**Consultation Response from
KC Waste Strategy (Refuse & Cleansing)**
PA no. & address: 2020/91746 Land off, Kenmore Drive, Cleckheaton, BD19 3EJ

Proposal: Erection of extra care development providing 80 apartments with associated communal facilities and landscaped gardens

Date Responded:
15/07/2020

Responding Ref:
WPN-20-041

Dwg No: 463/15(01)009 4

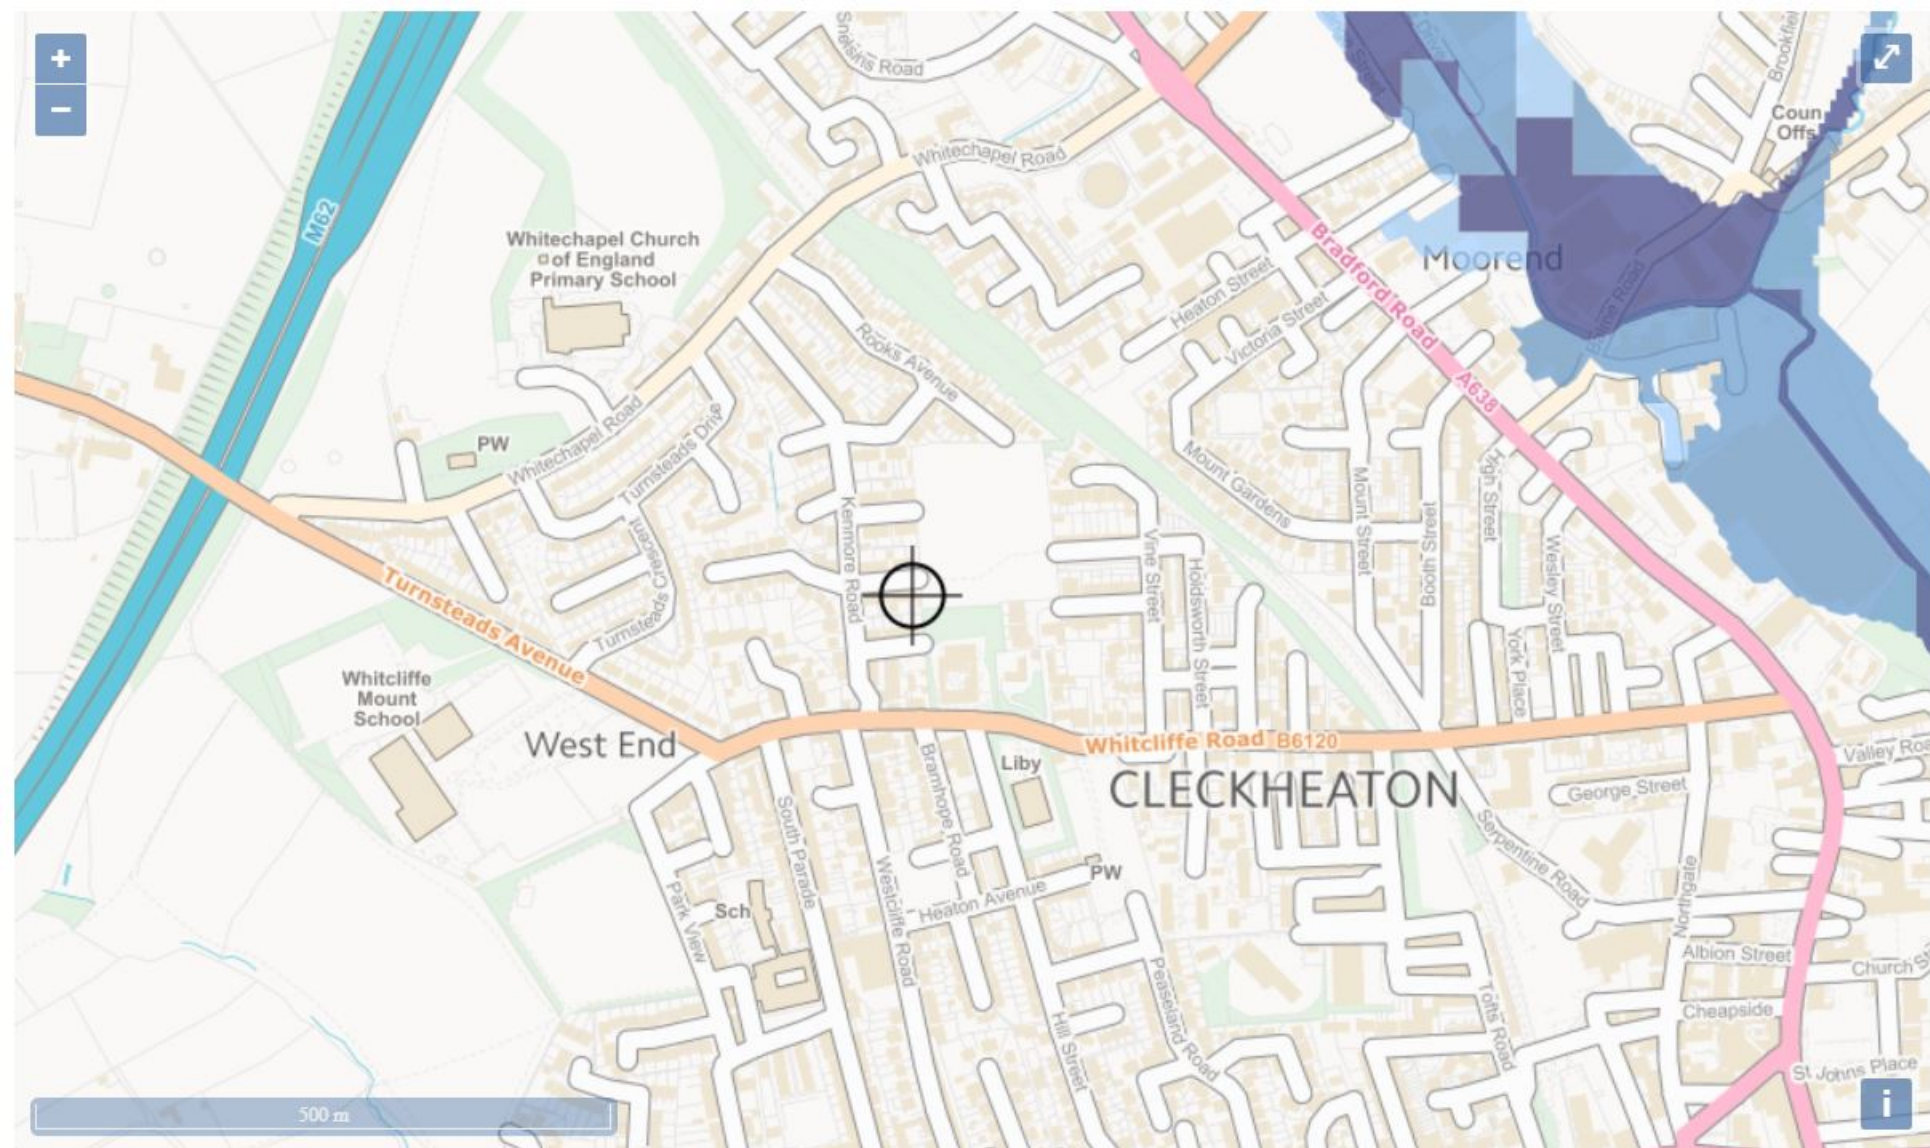
- Pre-submission advice was provided to the applicant. This stated that 26 x 1100ltr euro bins would be required to serve the development (13 for general waste and 13 for recyclables). The submitted layout plan (drawing number 463/15(01)009/6) shows a compound labelled as having 23 bins and there are only 22 shown. The Design and Access Statement states (section 4.3, page 34) correctly quotes the amount of storage space required. If the requirement for 26 bins is set to include 3 stored internally then it must be made clear that it is the responsibility of the management team to bring these out on collection days, and sufficient internal space for these 3 bins must be shown on the ground floor plans. Clarification on this discrepancy is sought.

- Additionally, the compound does not allow easy access to all the bins – either for users/site management or for collection crews. Bins being blocked in this way often results in waste not being placed in containers but on the floor, and if bins cannot be easily manoeuvred, this slows down the collection process making it inefficient. More circulation space is required around the bins so that they can all be accessed and manoeuvred out of the compound.

463/15(01)011/7 but not on drawing number 463/15(01)009/6. Where it is shown, it appears to conflict with the position of the external retaining wall and be of inadequate width. This door is vital to the easy manoeuvring of waste containers from the building to the external store via the upper patio, with no change in levels to negotiate to reach the external compound. Otherwise waste would have to be taken out through the building foyer. The door must be wide enough for the larger style bins to pass through. All drawings showing the ground floor arrangement should include this door.
